Written submission for Deadline 4, 13/01/2021

Richard Reeves, AP EA1N AFP 133 / IP 2002765

Responses, Questions, Corrections

RE The Applicants' Landfall Hydrogeological Risk Assessment 24/02/2021

| | Rev | Date | By | Comment | Approved: | AH | | | APFP Ref: 5(2) (o) | | Doc ref: 2.10 |

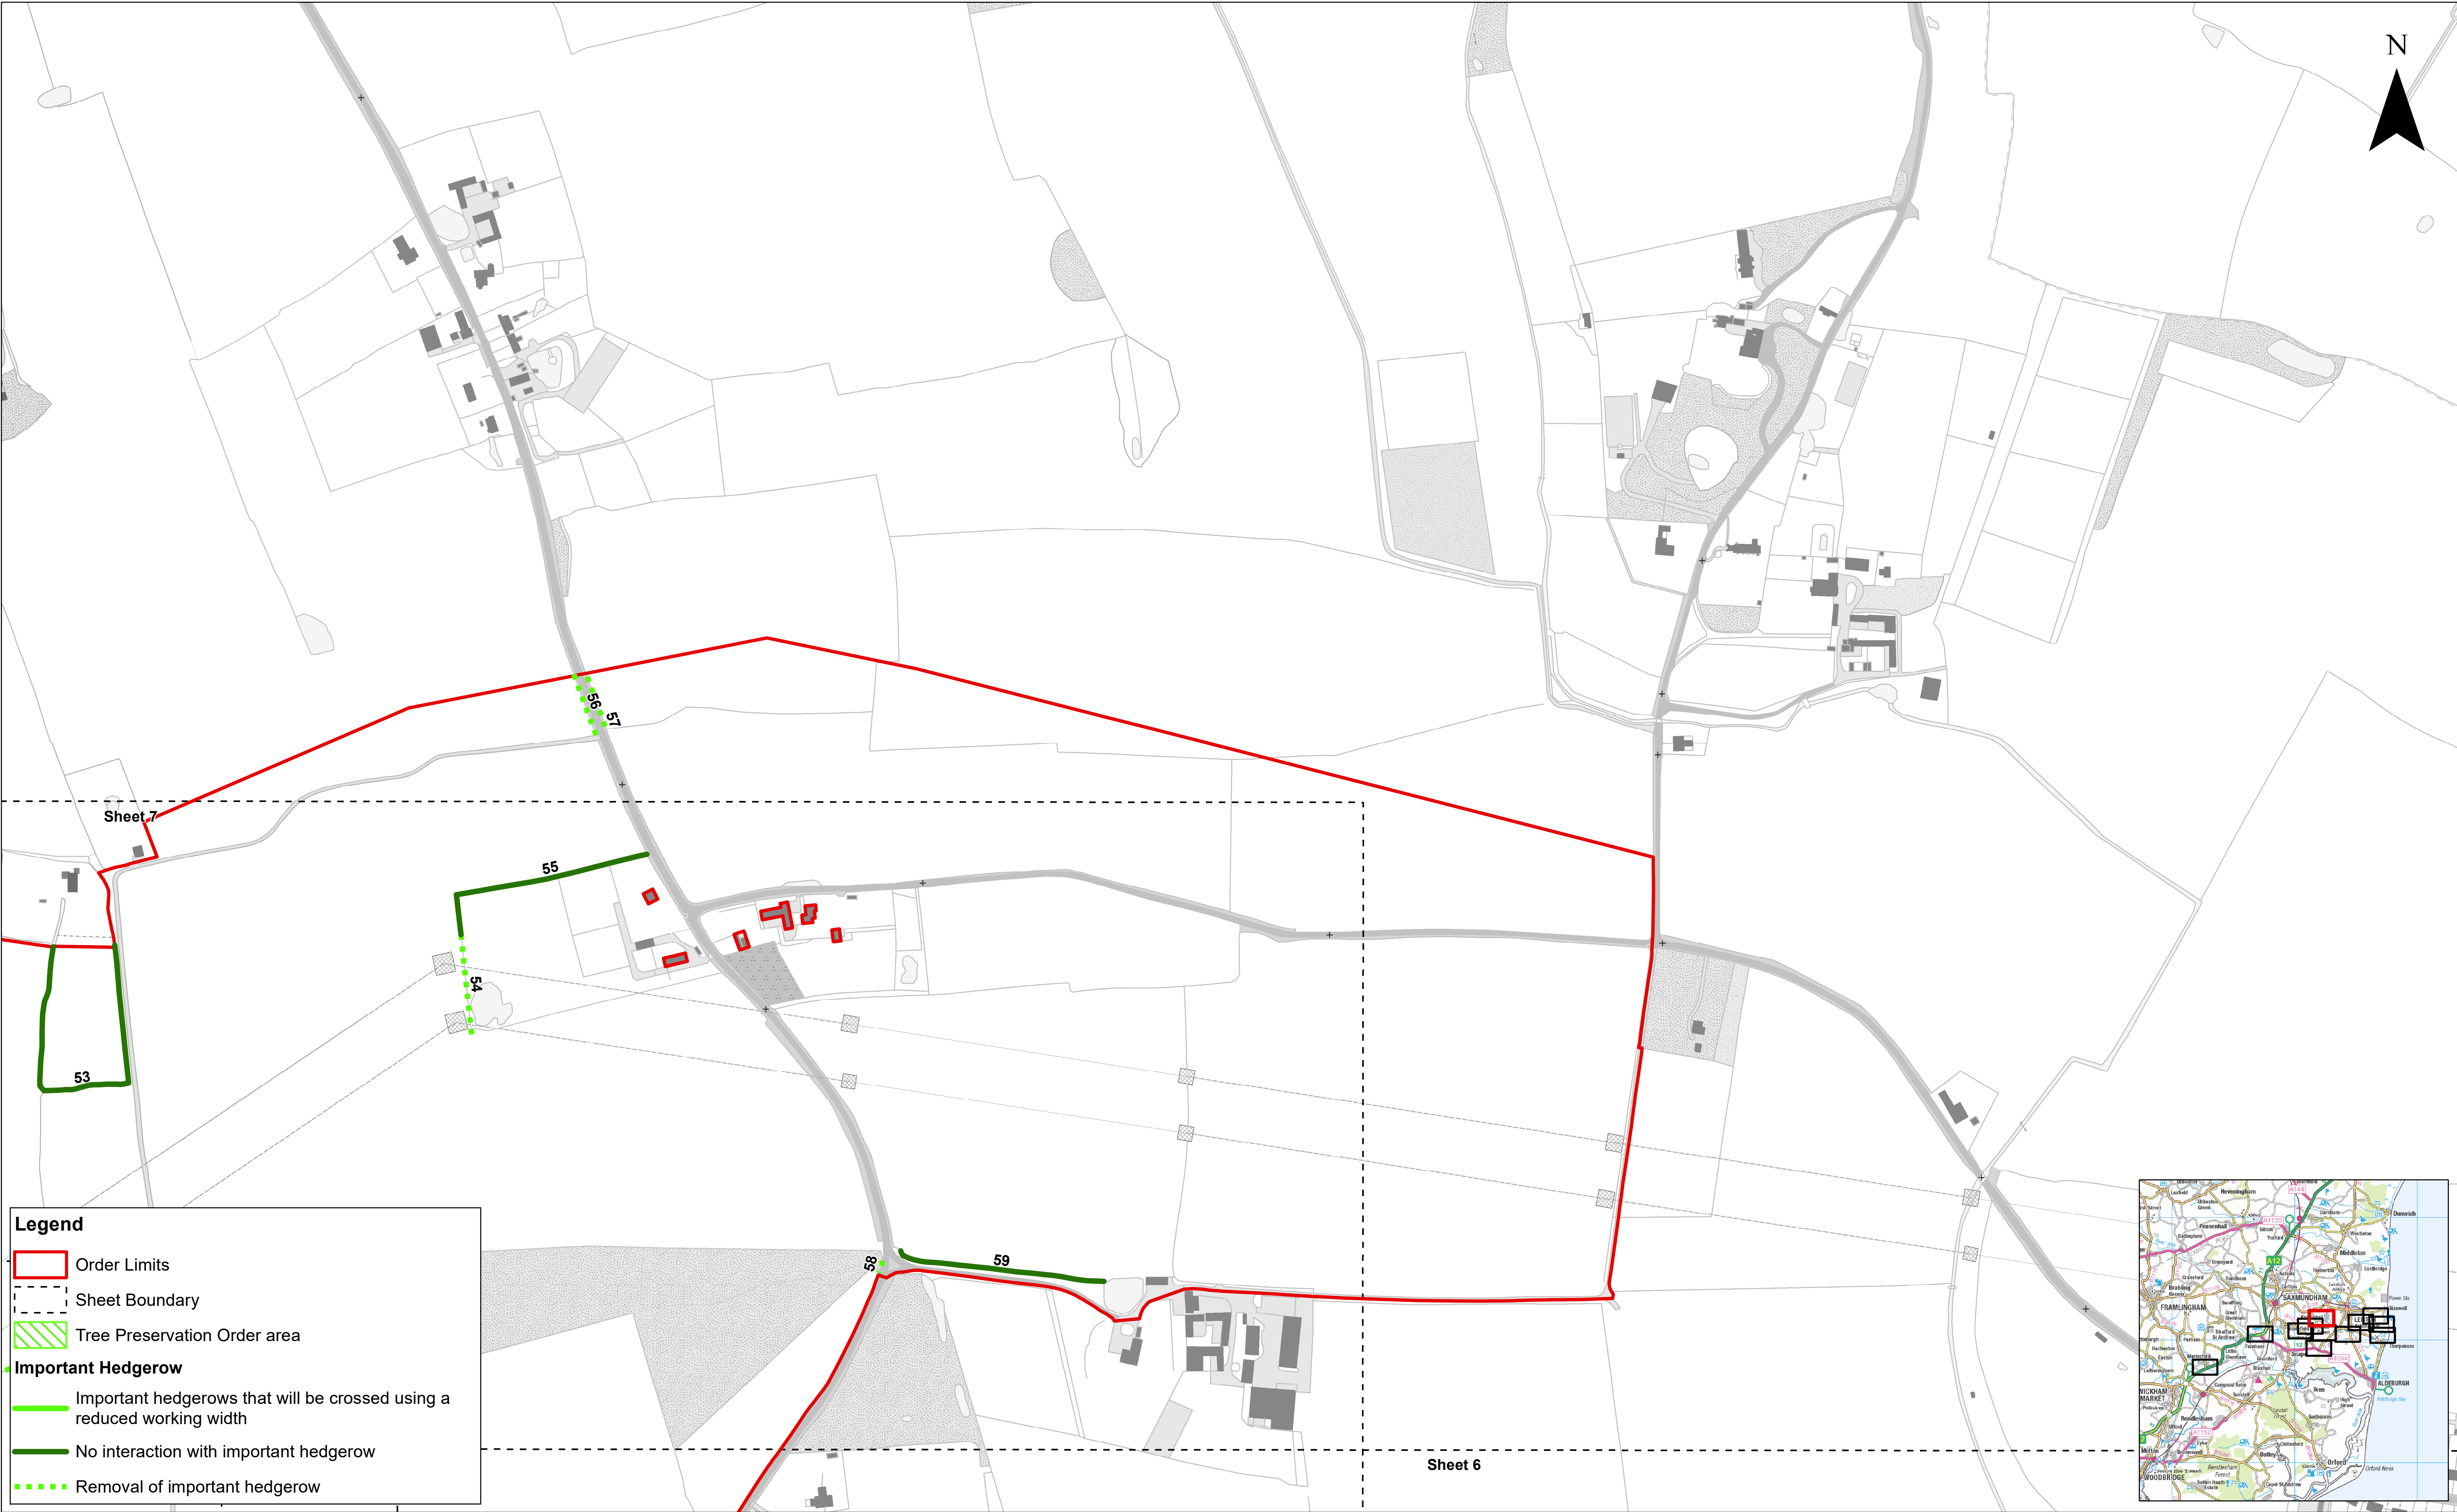
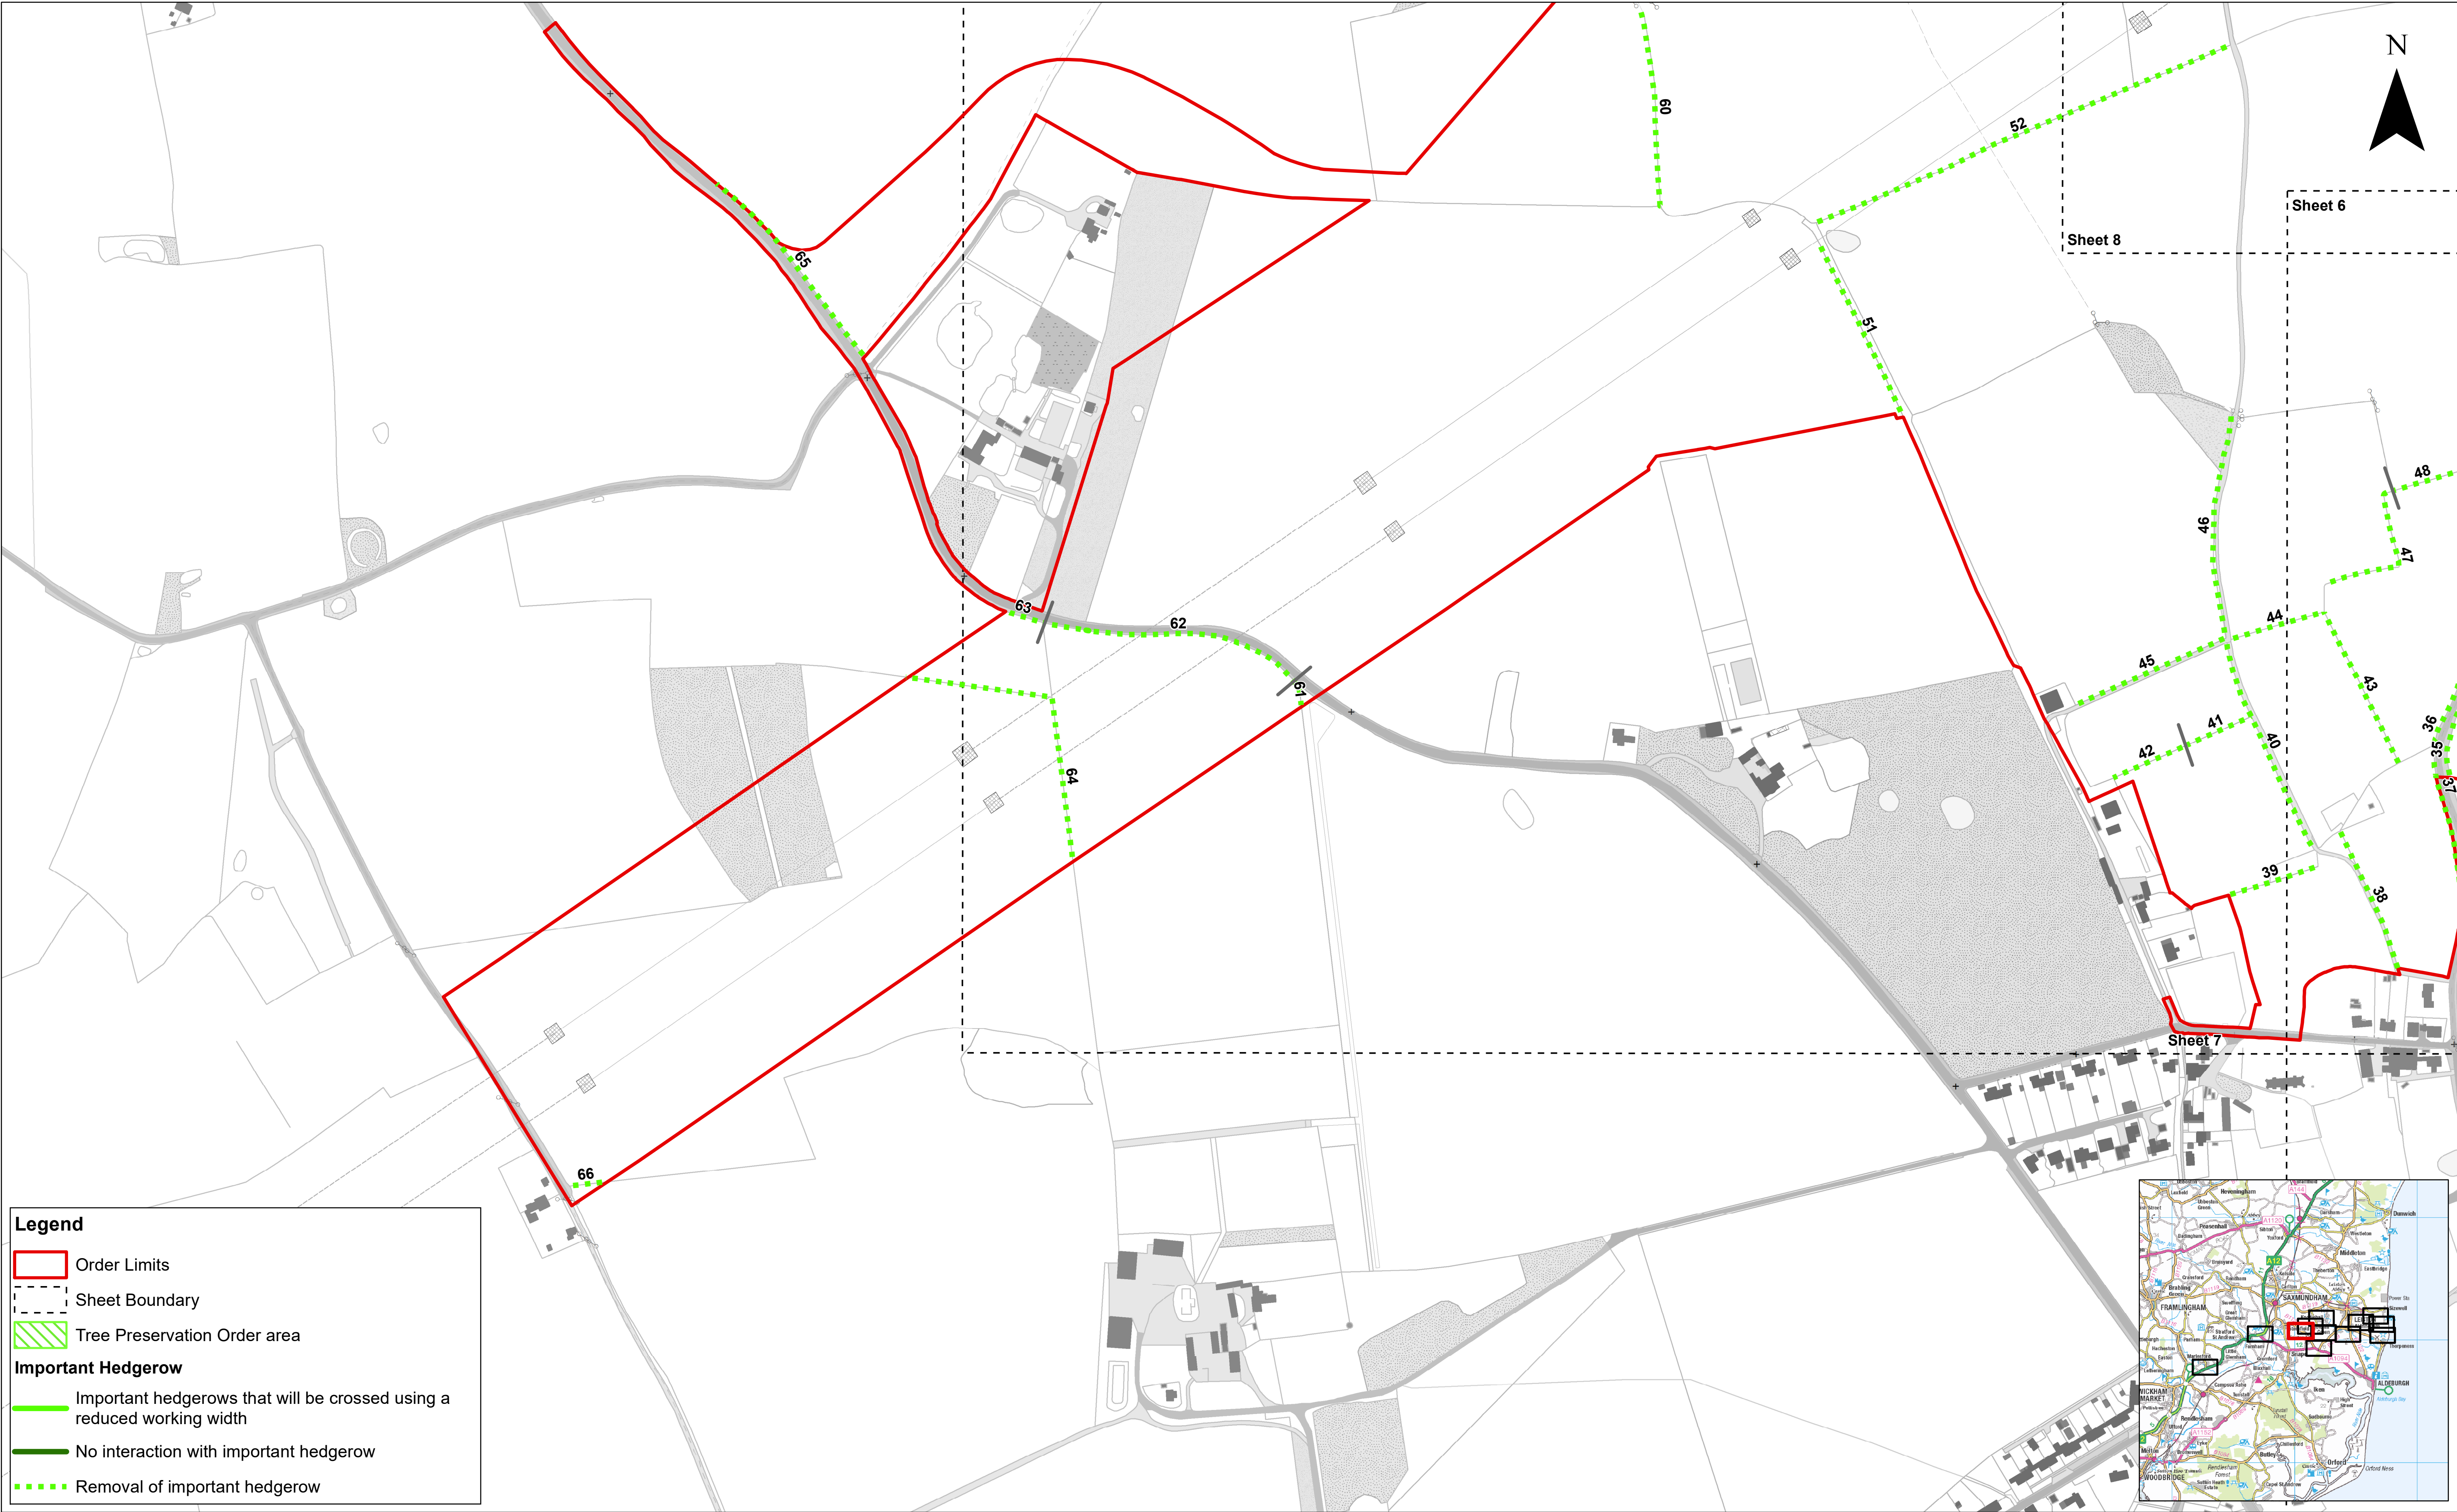
In Important Hedgerows 3 and 4 (scheduled for demolition) and the associated hedgerows linking and bordering plots 10;12;13;14 more than 40 species of wild flower have been recorded (cf my earlier submissions which include species recorded by Wardens volunteers and trustees over several decades). Amongst these flora are Red Valerian; Honeysuckle; Petunia; Sloe; Hawthorn; and numerous nectar-rich flowers. The species I name here are of particular relevance to several rare and protected species; three examples: the Hummingbird Hawk Moth; Lampyris Noctiluca (the Glowworm); Elephant Hawk Moth.
